From: Simon Davis <Simon.Davis@arun.gov.uk>
Sent: 20 April 2021 10:47
To: Planning.Responses <Planning.Responses@arun.gov.uk>
Subject: FW: Planning Consultation on: AL/20/21/PL

Further Landscape Officer comments

Thank you for sending through the extract from the landscape strategy which forms part of the Design and Access Statement (DAS Pages 29—40). This document is clear in that it *states play provision for all children between 4 and 8 years of age will be catered for within the LEAP as part of the central green space. It also details that it will contain equipment that allows a number of activities such as balancing, rocking, climbing, sliding and swinging in a way that encourages social play. Play opportunities will be provided through at least two formal play items** as well as the use of landscaping, levels and natural elements. The space will be fully accessible with inclusive play features and contain seating opportunities and bins in suitable locations.*

13 LANDSCAPING STATEMENT PROVIDED BY ALLEN PYKE

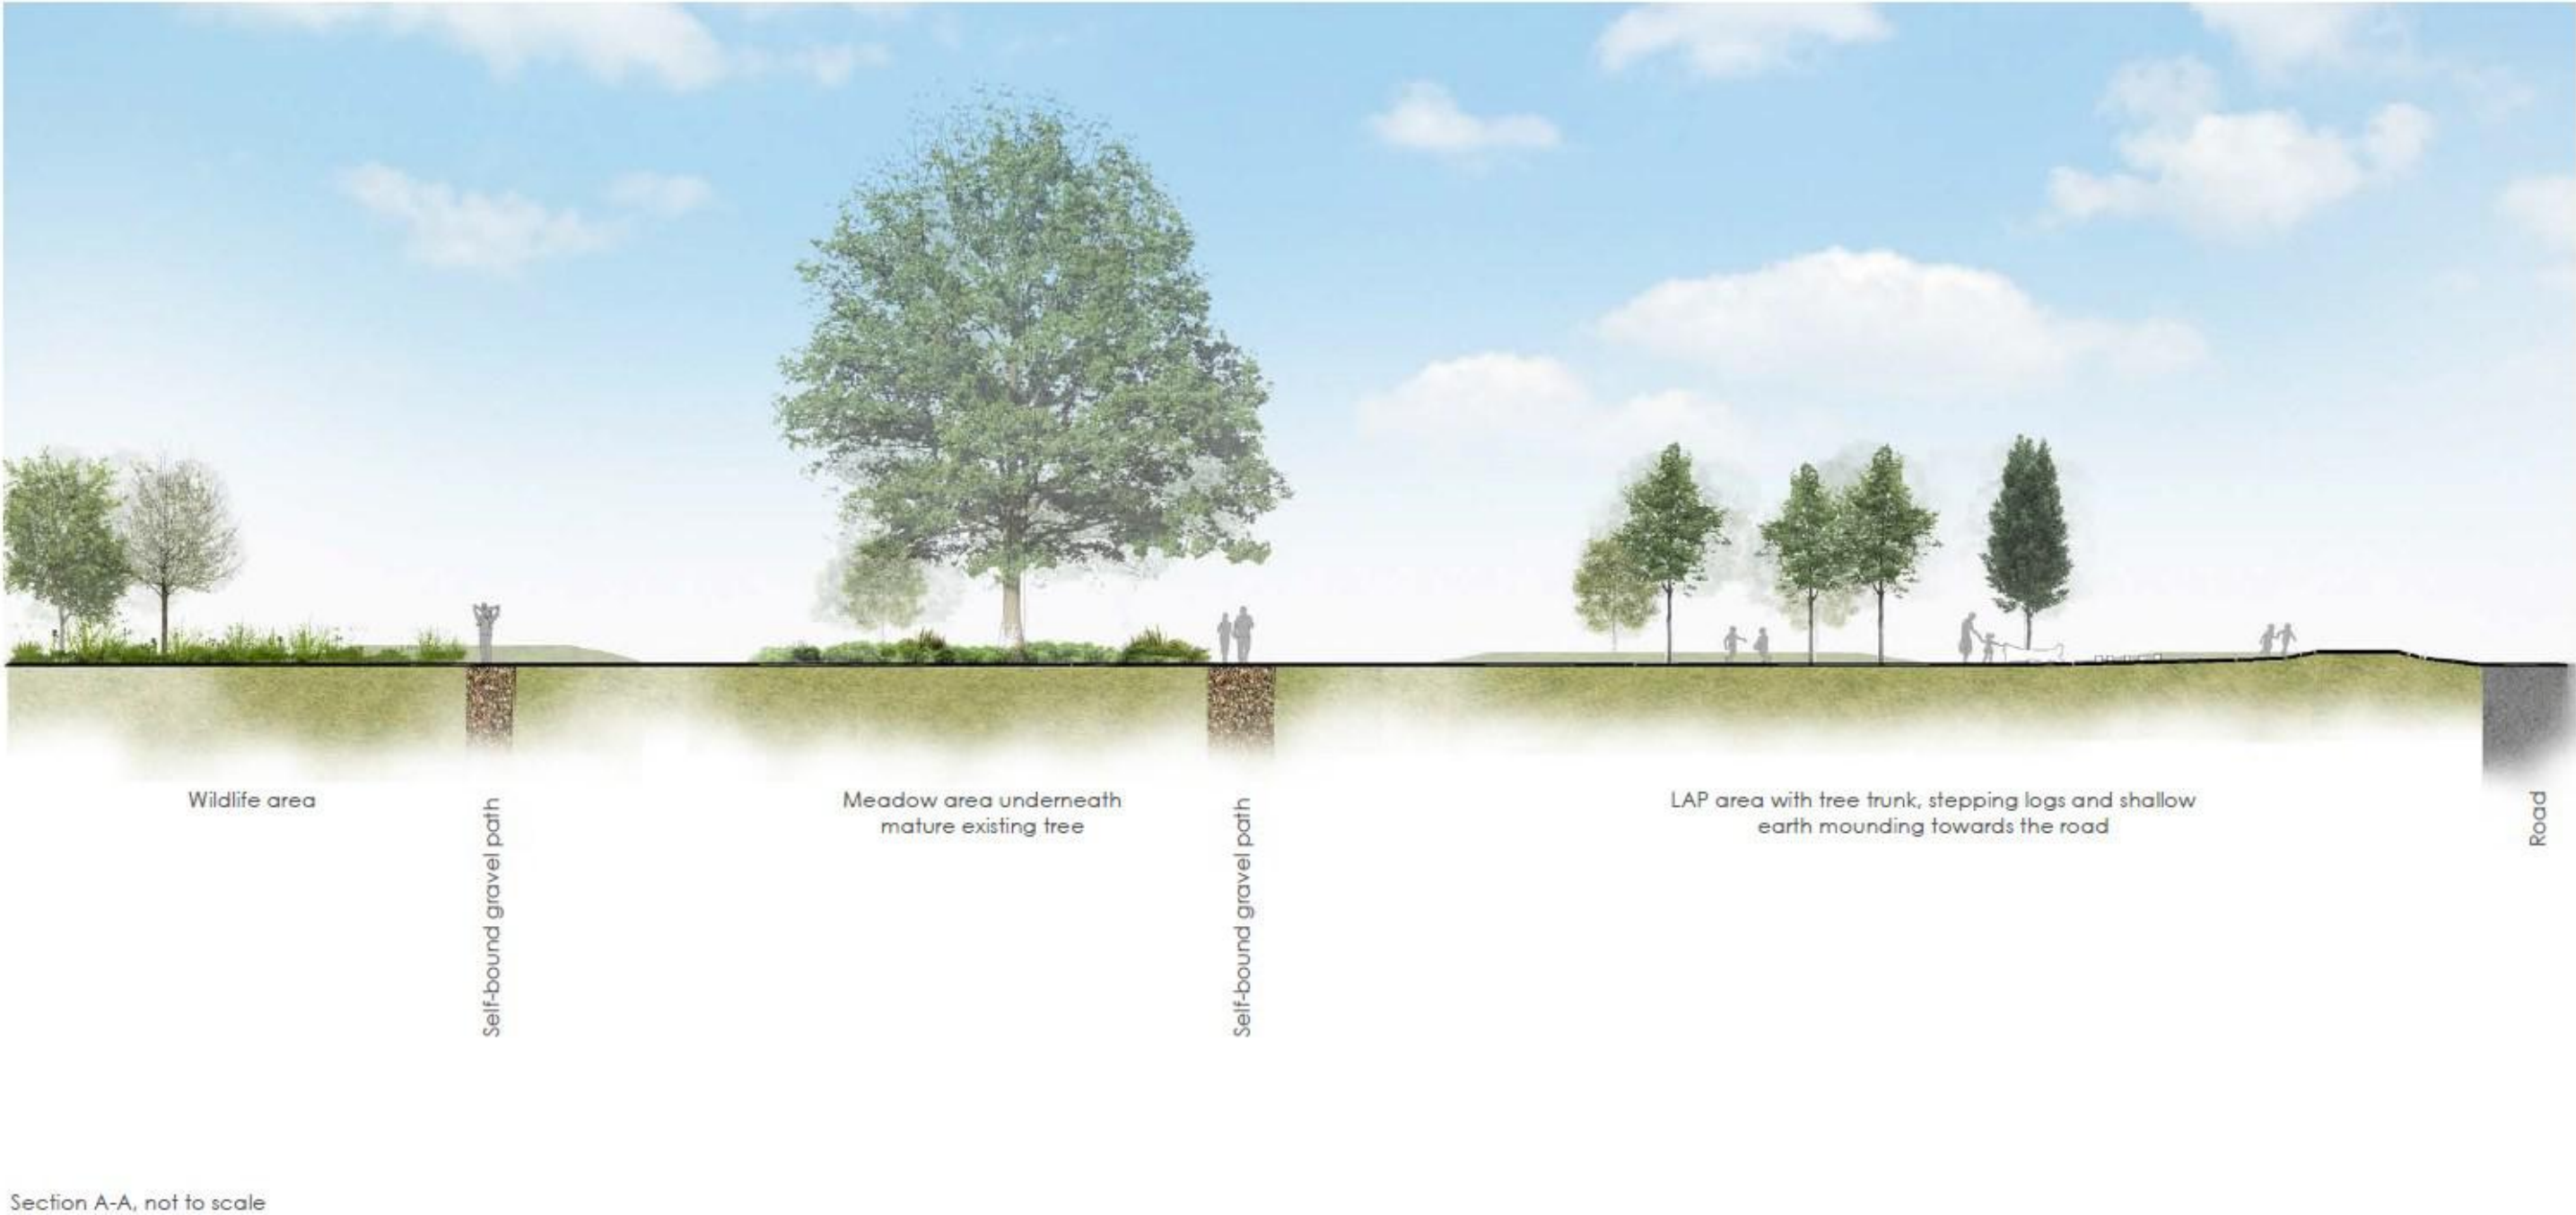
This detail is good to see, but will still need to be confirmed in plan form, particularly the detail *two formal play items* **. It will be expected that a LEAP will provide six play experiences with the more natural elements in particular, incorporated into the LAPs.

I am satisfied that the detail is sufficient for this stage, but will require further detail to be provided as reserved matters or condition.

My first thought however is that the drawings remain unclear as to where and what play is being provided in plan form. The drawing would always take precedence and therefore needs to be clear, despite what is detailed in the DAS.
